Application for a non-material amendment following a grant of planning permission.

Garages Site between 15b & 17-17a Northdown Close, Ruislip

Drawing Title:
APPROVED AFTER APPEAL & PROPOSED
NON-MATERIAL AMENDMENT GROUND FLOOR PLAN

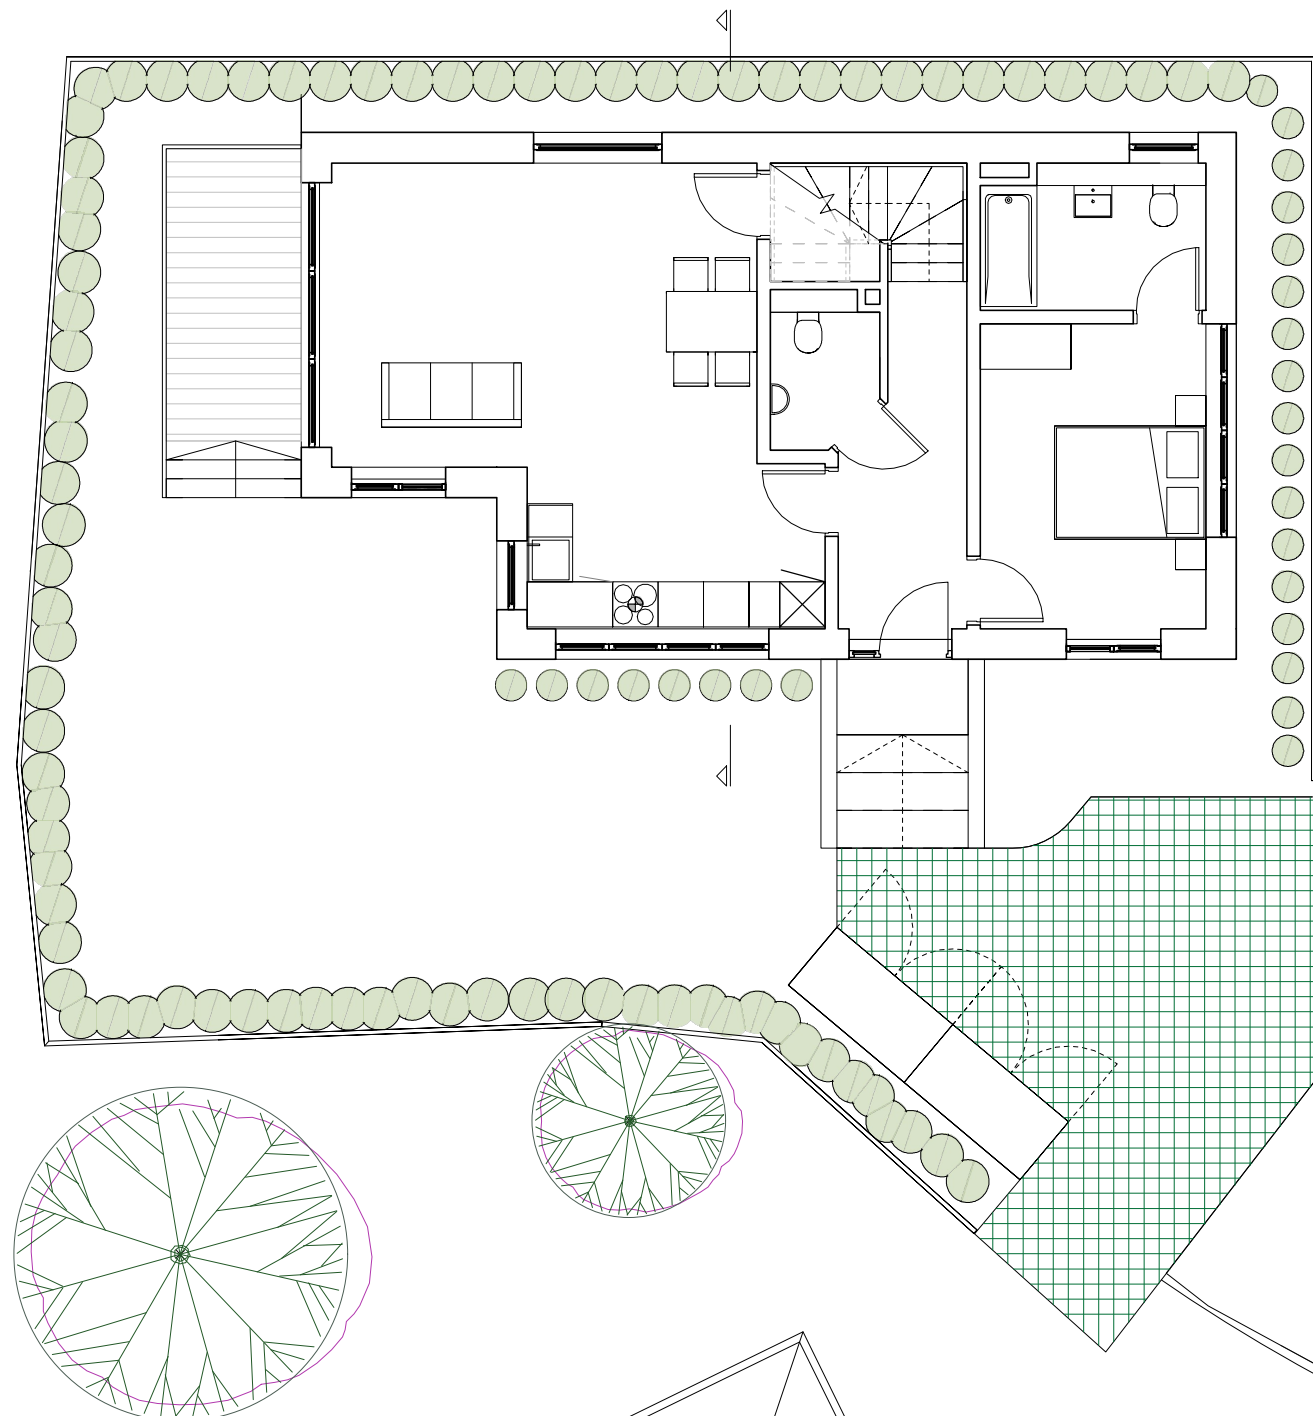
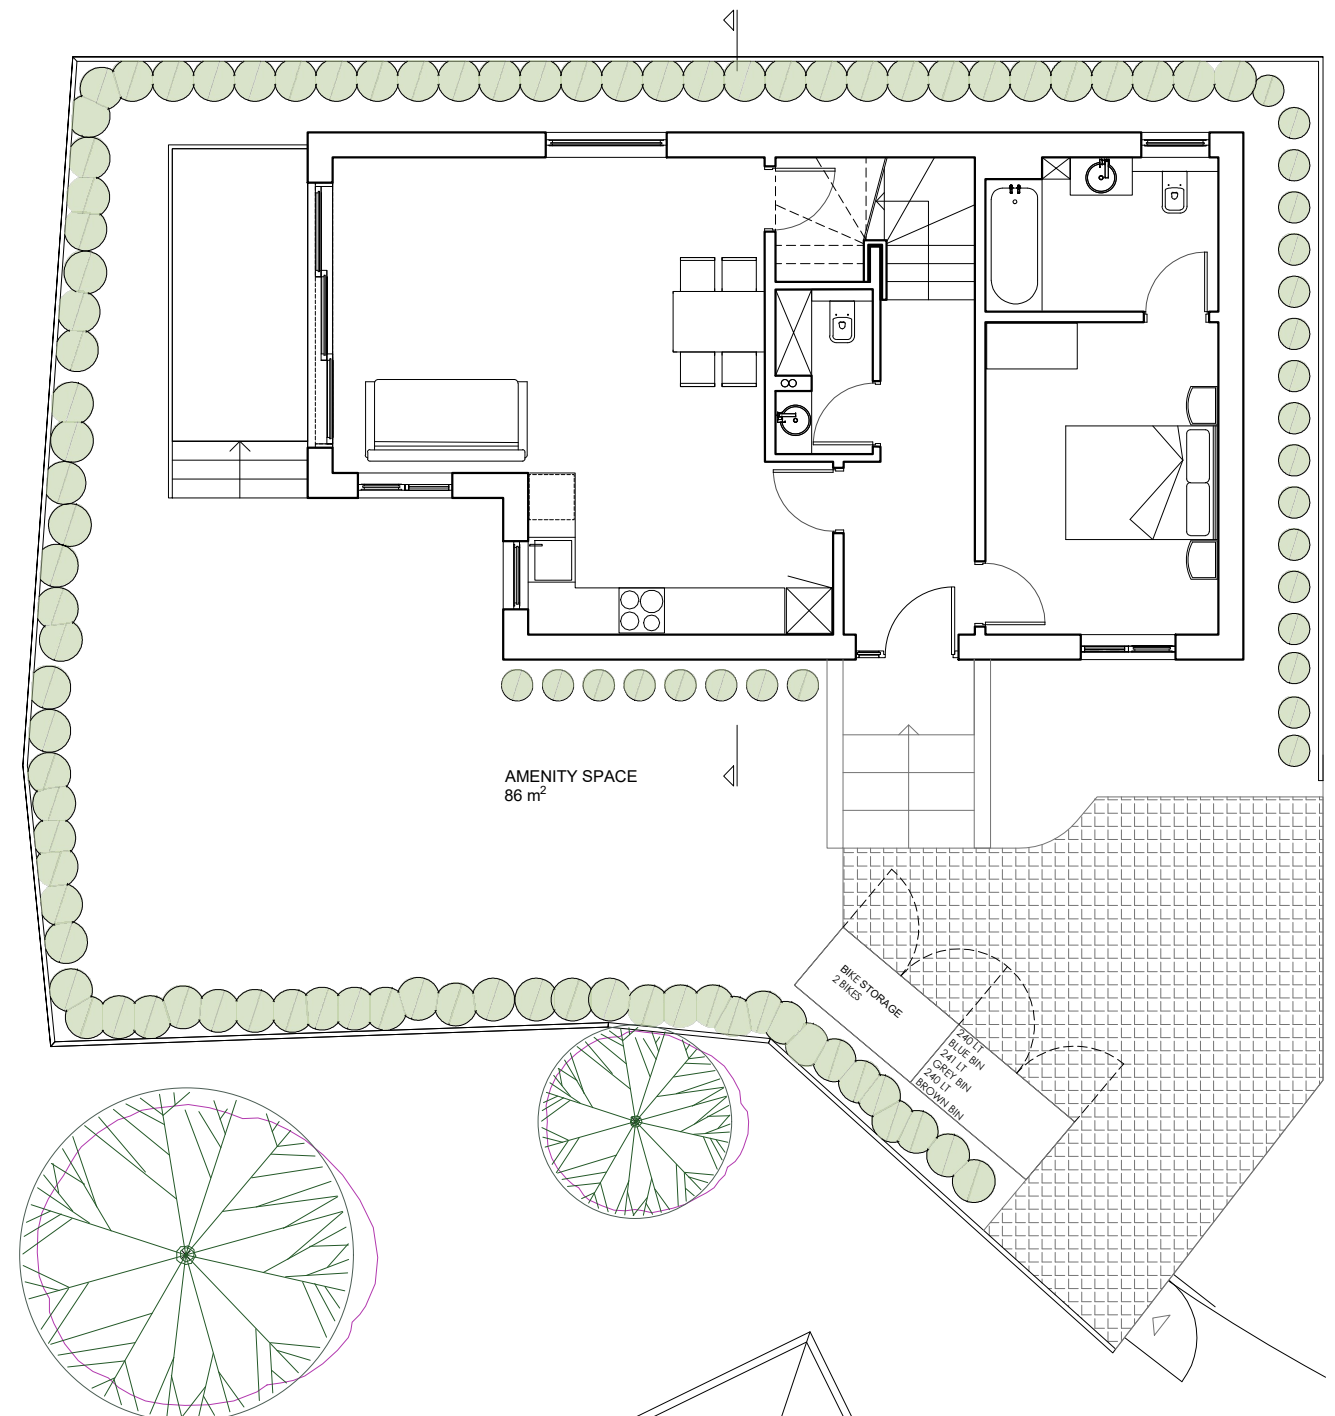
- Removal of the 4 rooflights as there is no proposed loft and there is no need for openings on the roof.
- Removal of the 4 windows on the front façade on the ground floor, where the kitchen is located. These windows are too tall and not practical for the use of the kitchen. The kitchen/living/dining area will receive enough light from the rest of the windows.
- Removal of the 4 windows on the ground floor and 4 windows on the first floor on the south side elevation. These windows are too tall to be practical. The rooms that they facilitate will receive enough light from the windows on the other sides.
- No changes on the landscaping.
